Application No: EP/9/22/HH
Site Address: 4 Selhurst Close East Preston BN16 2SR
Description of works: Single storey front extension and conversion of integral garage.

Thank you for your internet representation made on 4th March 2022 which has been recorded as an objection with the comments as follows:

Drawing Name
Ground Floor Plan -
Proposed

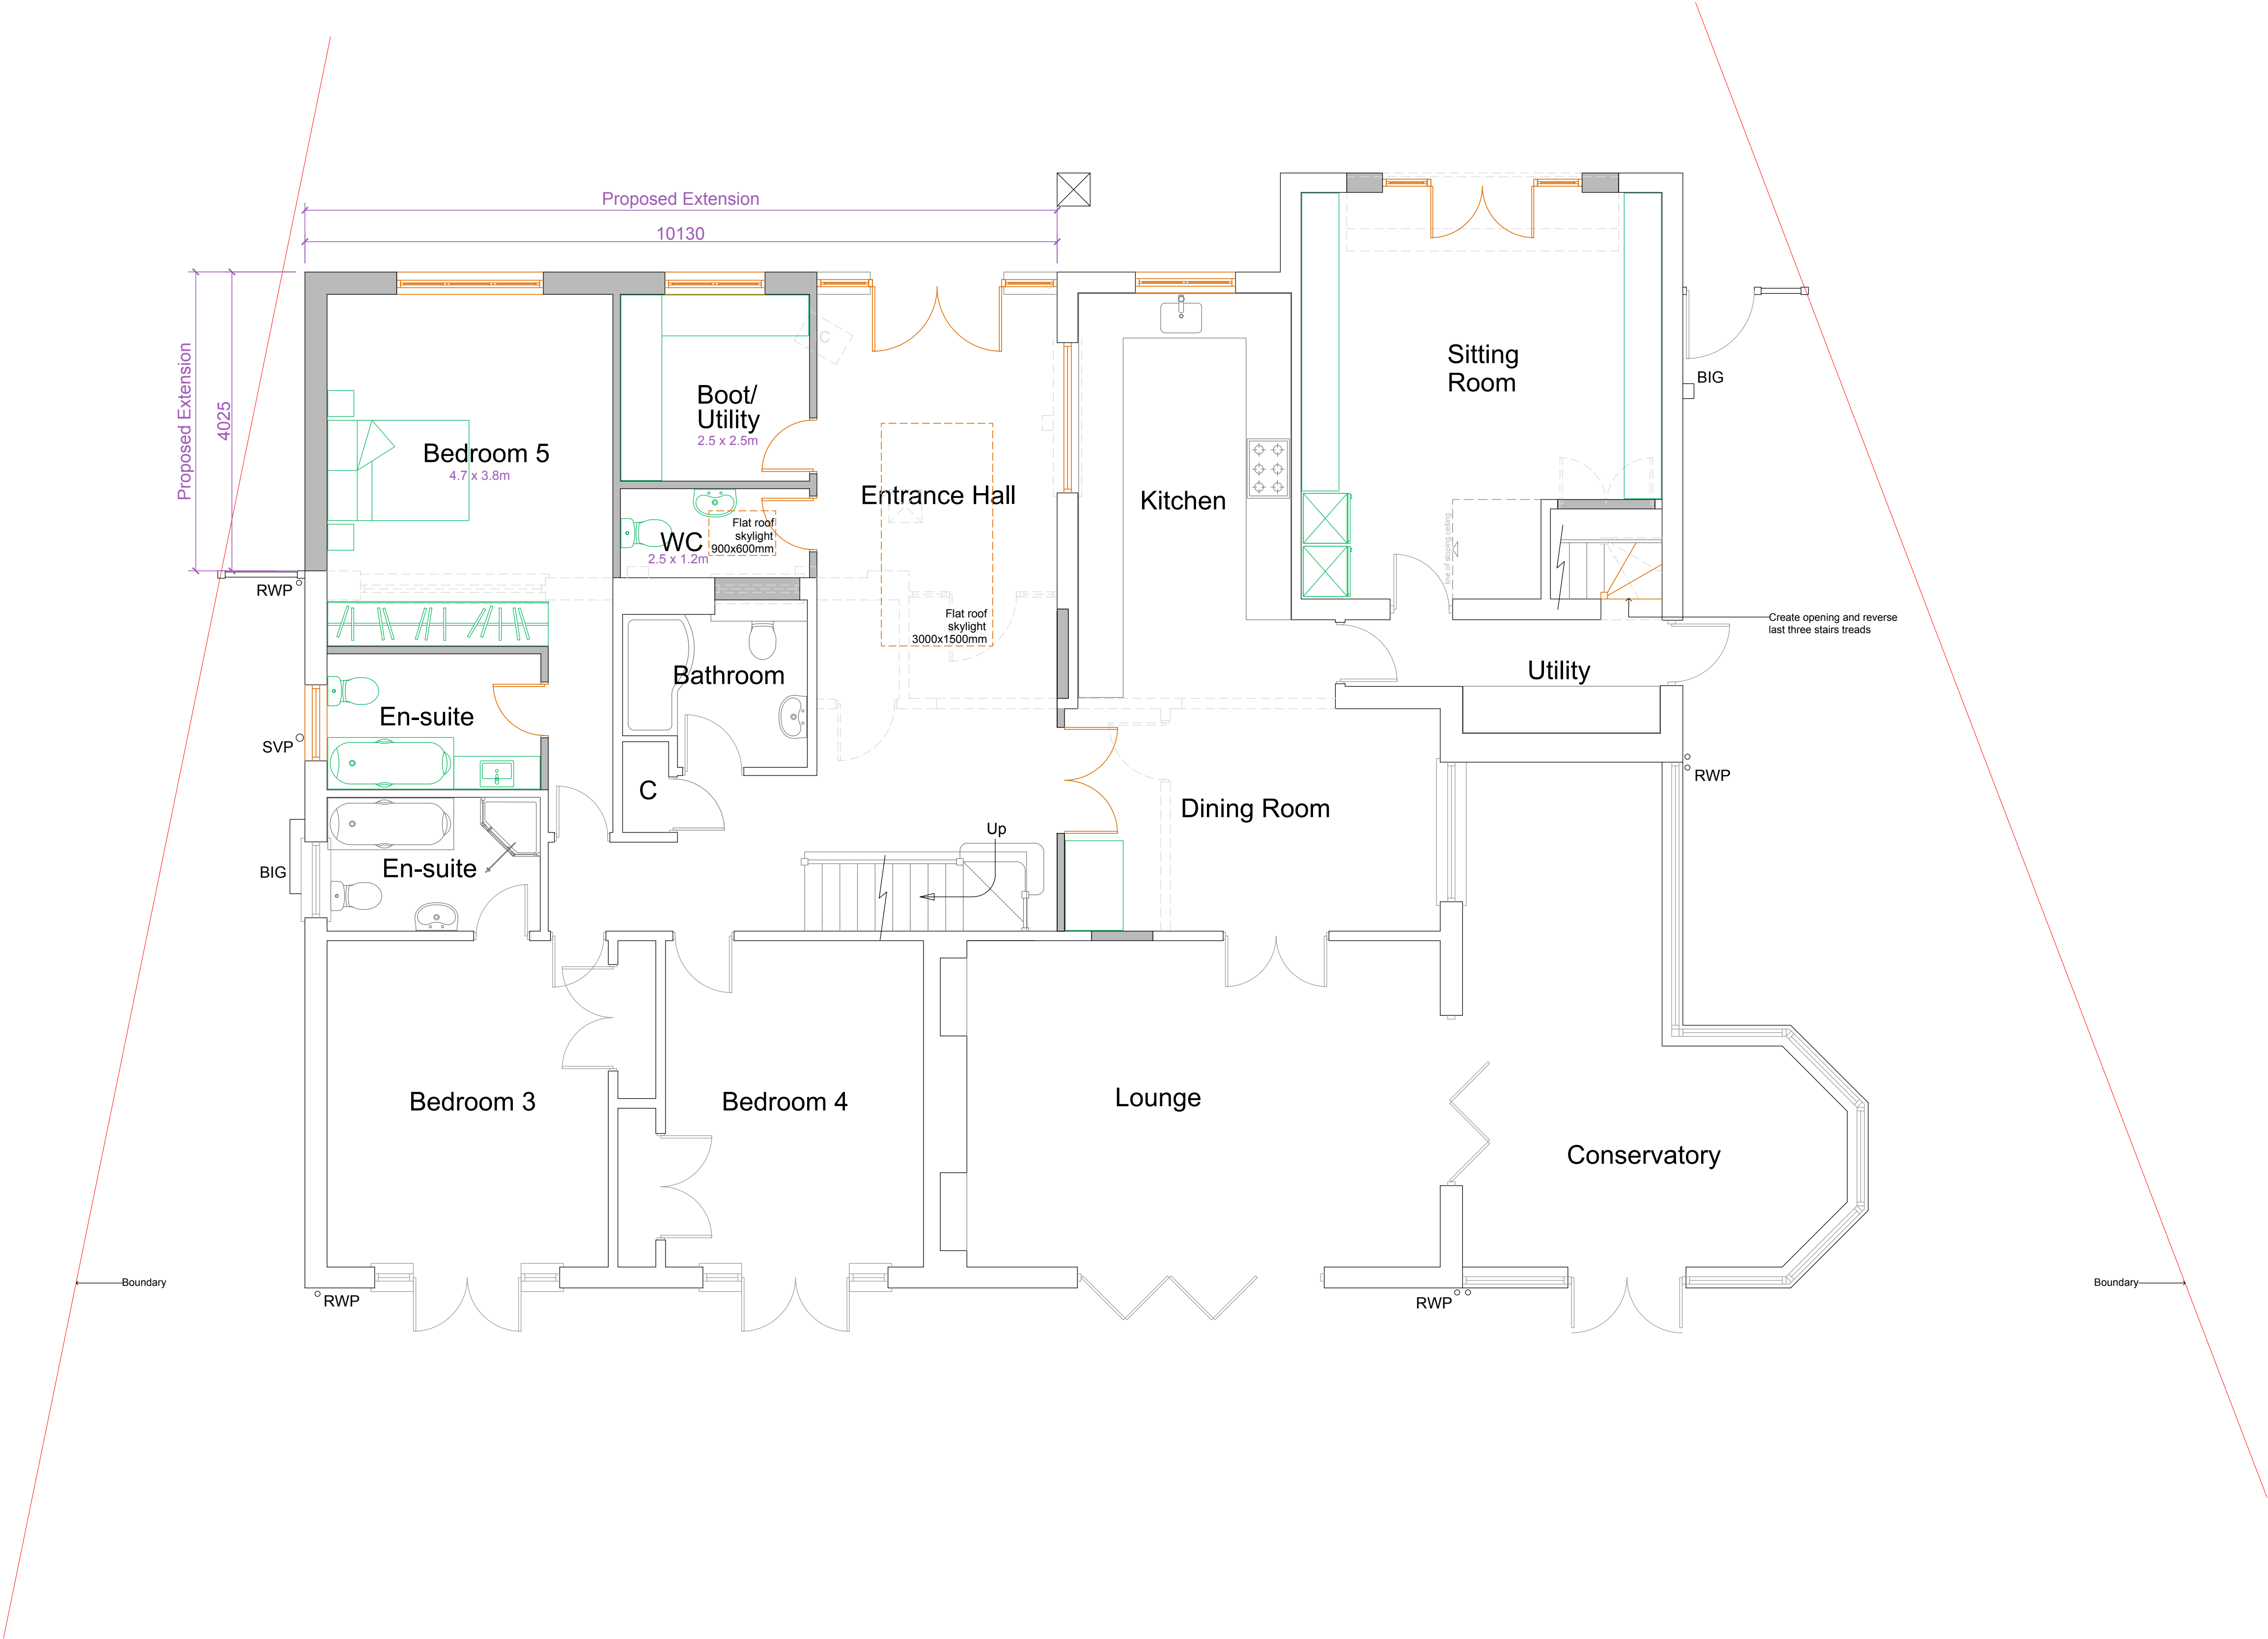
The committee AGREED it would object to this iteration of the proposals for this site as it felt the proposal was still close to overdevelopment of the plot. The committee is still concerned the proposal will bring the property too close to the northern boundary of the plot. The committee felt these reasons made the proposal contrary to Policy D DM1 of the Arun Local Plan.
